CONSULTANT ADVICE

Date	23 May 2018
Project	Gledswood Hills Public School
Project Number	16344
CA Ref.	CA-01
To	Marco Luci
Company	Perumal Pedavoli Architects
From	Dishana Liang
Subject	External Paths of Travel

External paths of travel have been reviewed against the BCA requirements and AS 1428.1(2009).

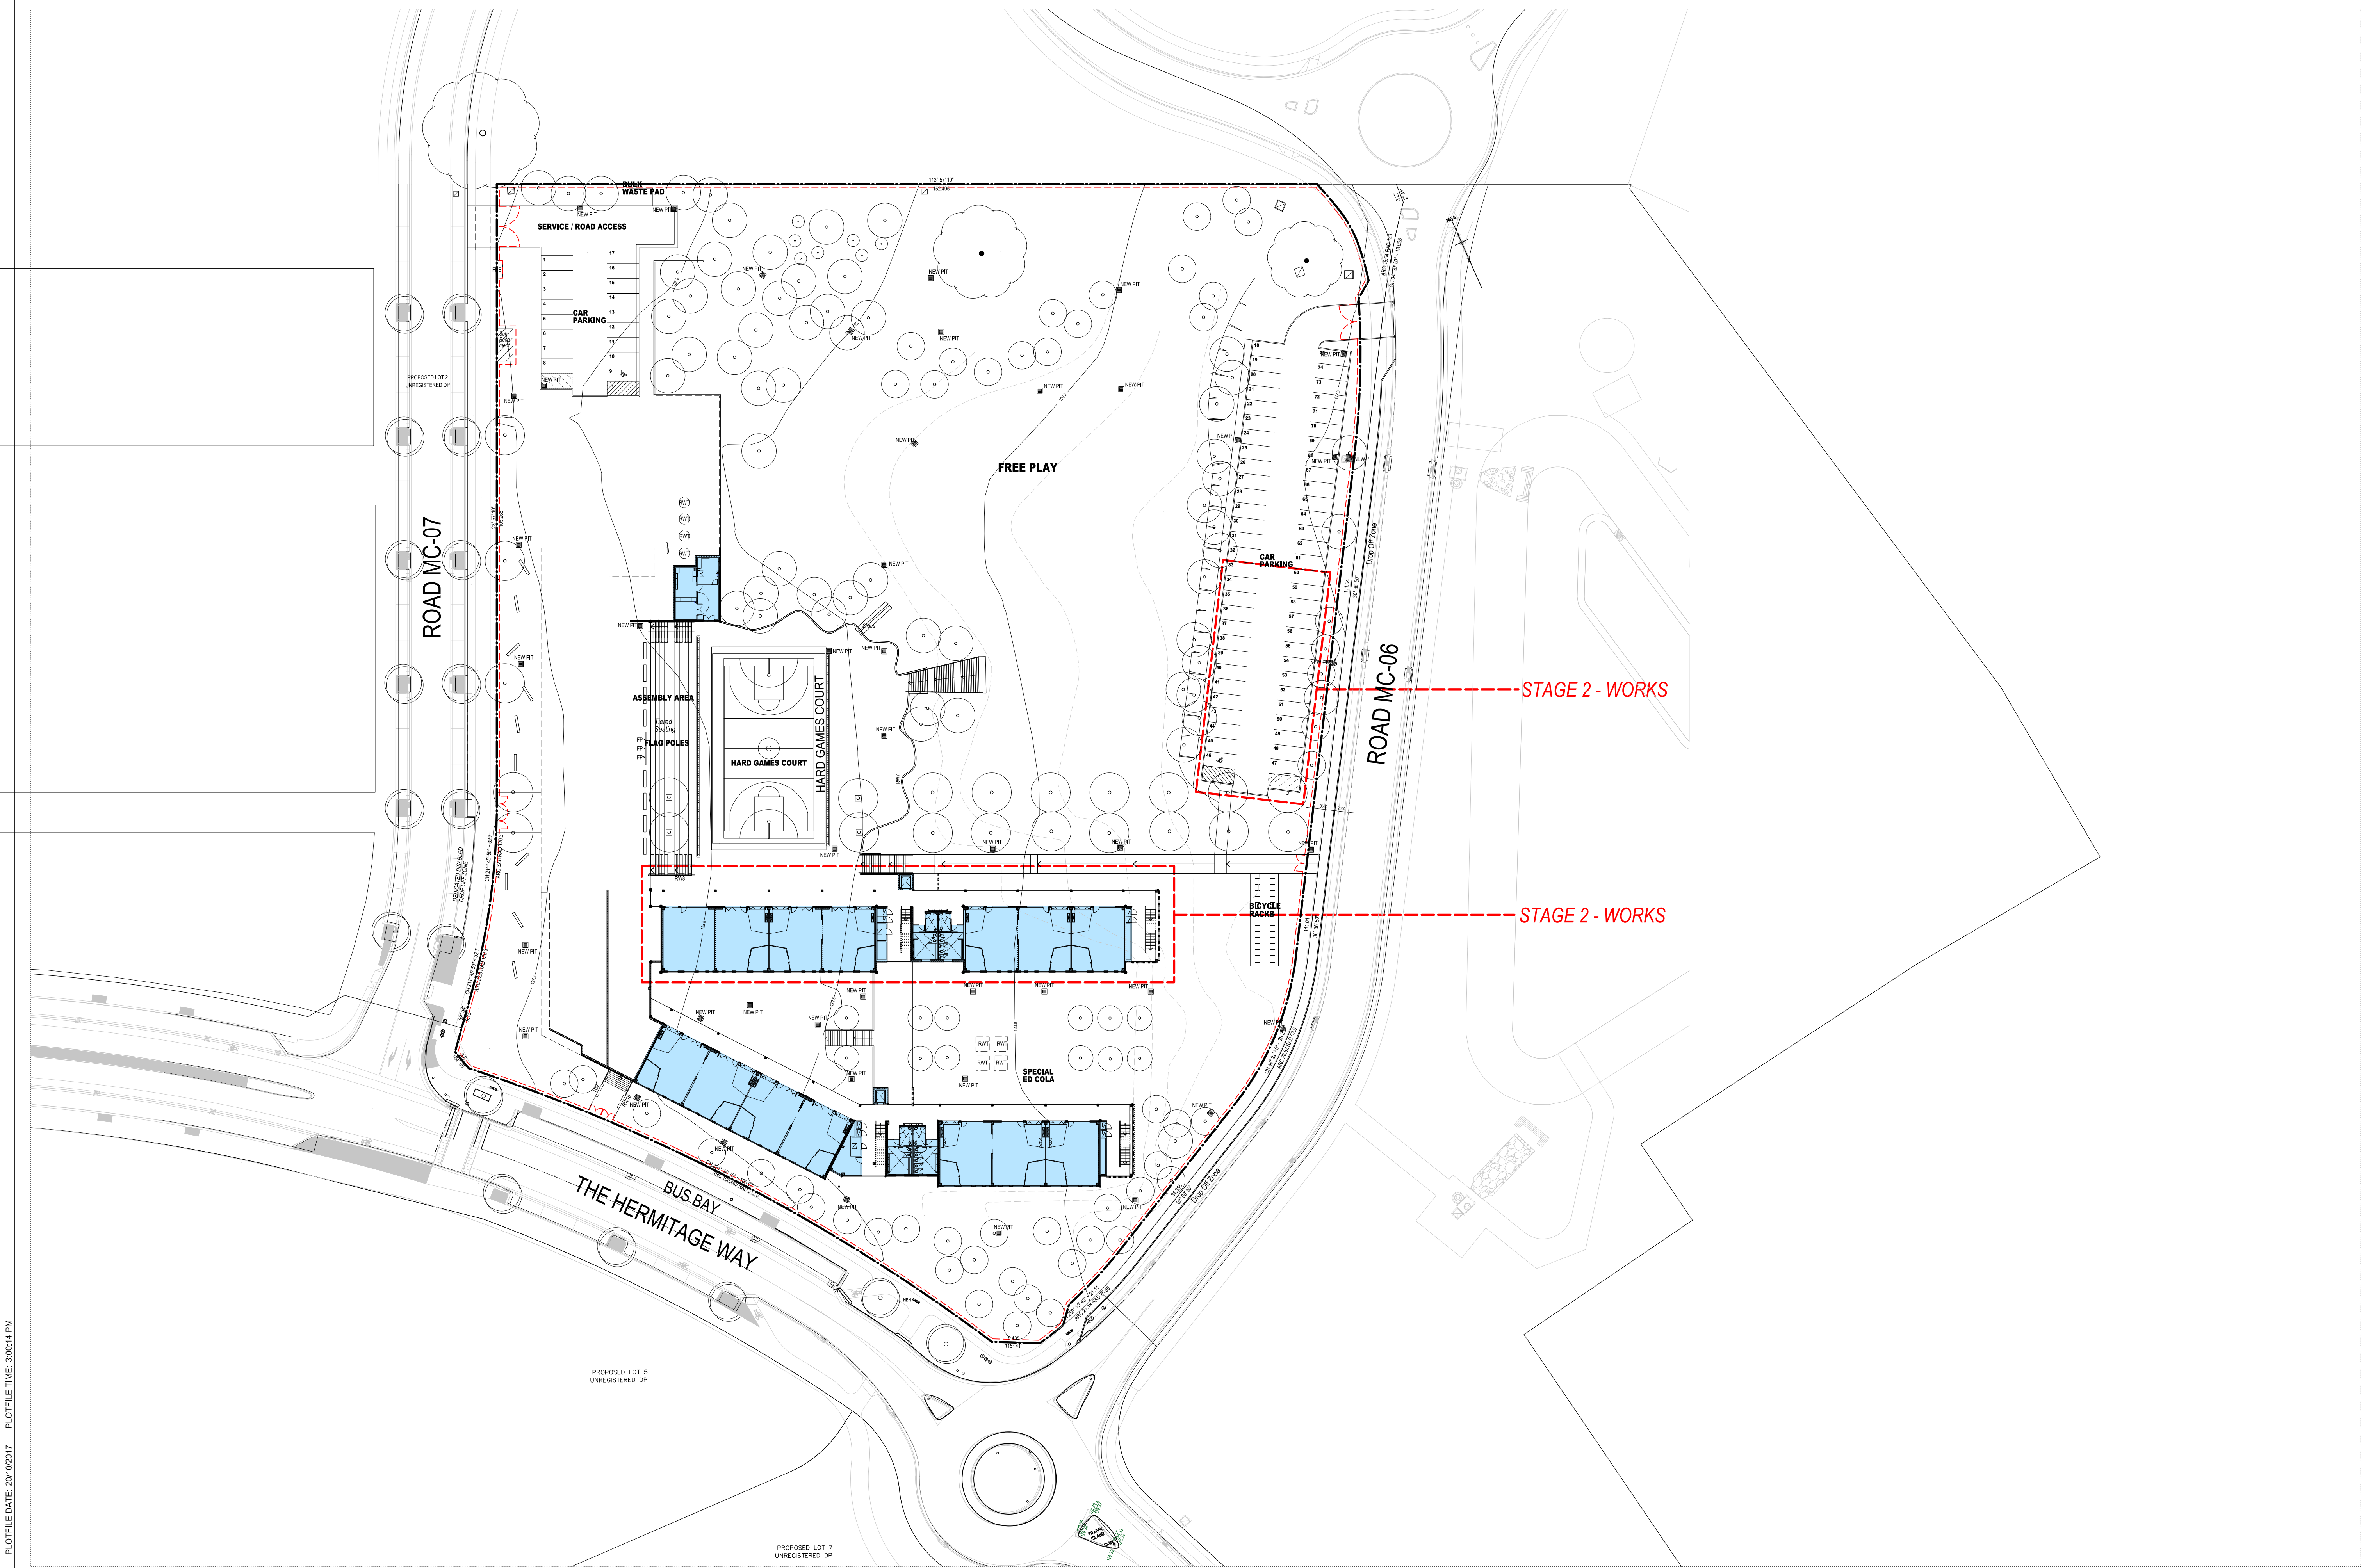
The current documentation provides appropriate paths of travel to connect all buildings from two of the three pedestrian entries at the allotment boundary, from accessible carparking spaces at both carparks, as well as between all buildings. Refer attached marked plans indicating locations of accessible pedestrian paths of travel.

In relation to the pedestrian entry points from the allotment boundary, it is noted that the site is provided with three pedestrian entries, one off 'Road MC-07', one off 'The Hermitage Way' and another off 'Road MC-06'. The pedestrian entry off The Hermitage Way will not be accessible due to provision of stair access only. It is noted that there is a significant fall across the site which has led to the provision of stair access. A performance solution will be developed to address this entry on the basis of the following:

- Distance between pedestrian entry which is not accessible (off Hermitage Way) is not a significant travel distance from the accessible entries (approximately 66m). This is comparable to the 50m distance permitted between accessible and non-accessible entries into a building. It is considered that the maximum distance to travel from the non-accessible site entry to an accessible one is acceptable.
- It is noted that parents or children will generally be familiar with the school site and will utilise the entries which best serve their needs.
- The general drop off zones are located off Road MC-06 and Road MC-07, where accessible site entries are located.
- All carparks are provided with accessible path of travel.

A formal performance solution report will be prepared to demonstrate compliance with relevant Performance Requirement DP1 to confirm that access will be provided to the degree necessary. This report will be submitted for review and approval by the Principal Certifying Authority.
